**Dubbo Zirconia Project (SSD-5251)
Environmental Impact Statement Review**

NSW Trade & Investment, Regional Infrastructure & Services, Division of Resources & Energy (DRE) has reviewed the Dubbo Zirconia Project Environmental Impact Statement (EIS) as proposed by Australian Zirconia Limited and provides the following comments. These comments are limited to the information in the EIS relating to mineral resources, rehabilitation and mine closure.

Figure 2.1
INDICATIVE DZP SITE LAYOUT

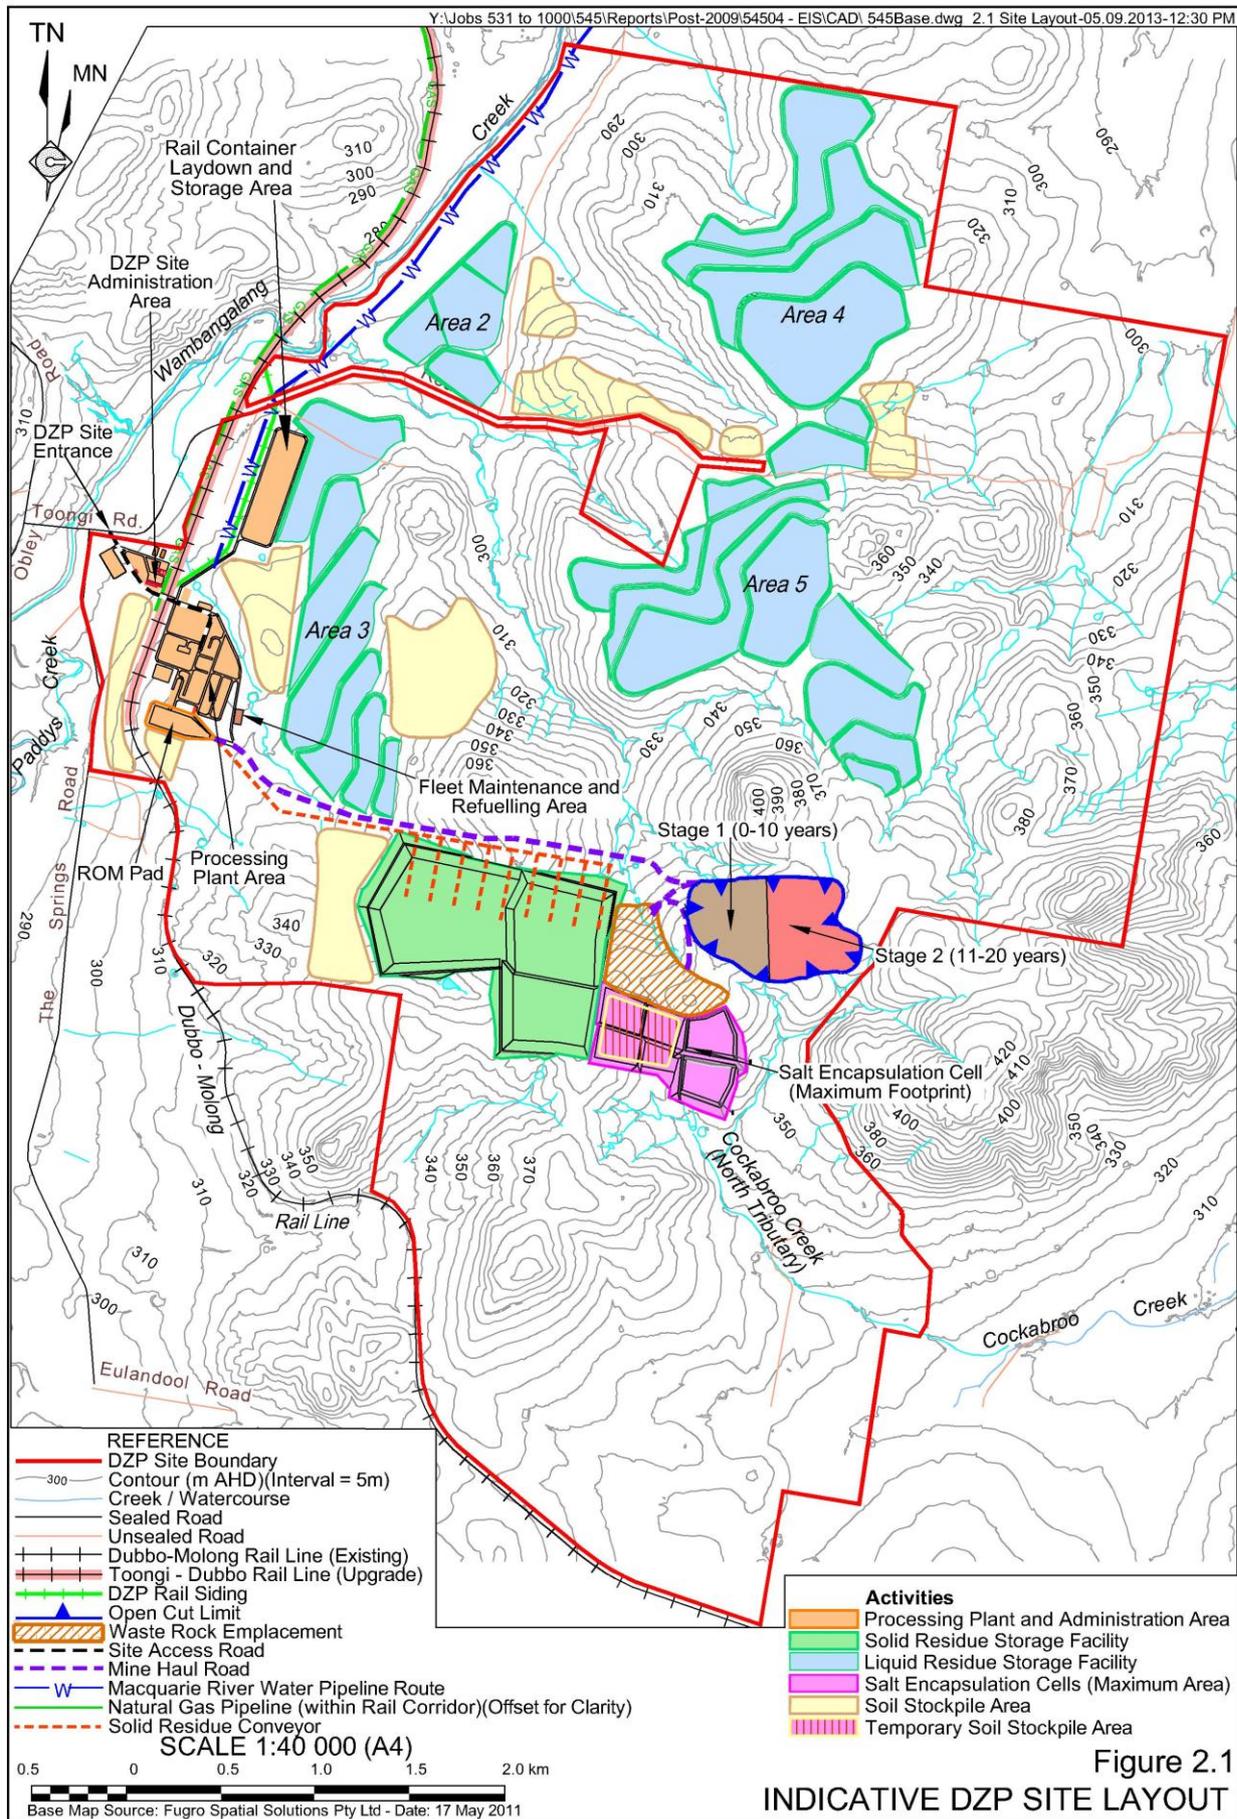
In Figure 2.1 *Indicative Final Land Use*, the final land use for the processing and administration areas are shown as potential industrial land uses. Similarly, in Section 2.17.6.2 *Decommissioning Activities*, proposes to retain the rail line infrastructure, Macquarie River pipeline, natural gas pipeline, electricity transmission lines, transformers and substations and the access road for potential industrial land uses.

DRE prefers the post mining land use to be consistent with existing land use strategies in the region. As a future industrial use has not been approved the proponent must assume these areas will be rehabilitated to a land use consistent with existing surrounding land uses and zonings, which is predominantly grazing agricultural use. Therefore the majority of the retained infrastructure is not compatible with that use.

The proponent must develop a final land use that is consistent with existing surrounding land uses and zonings.
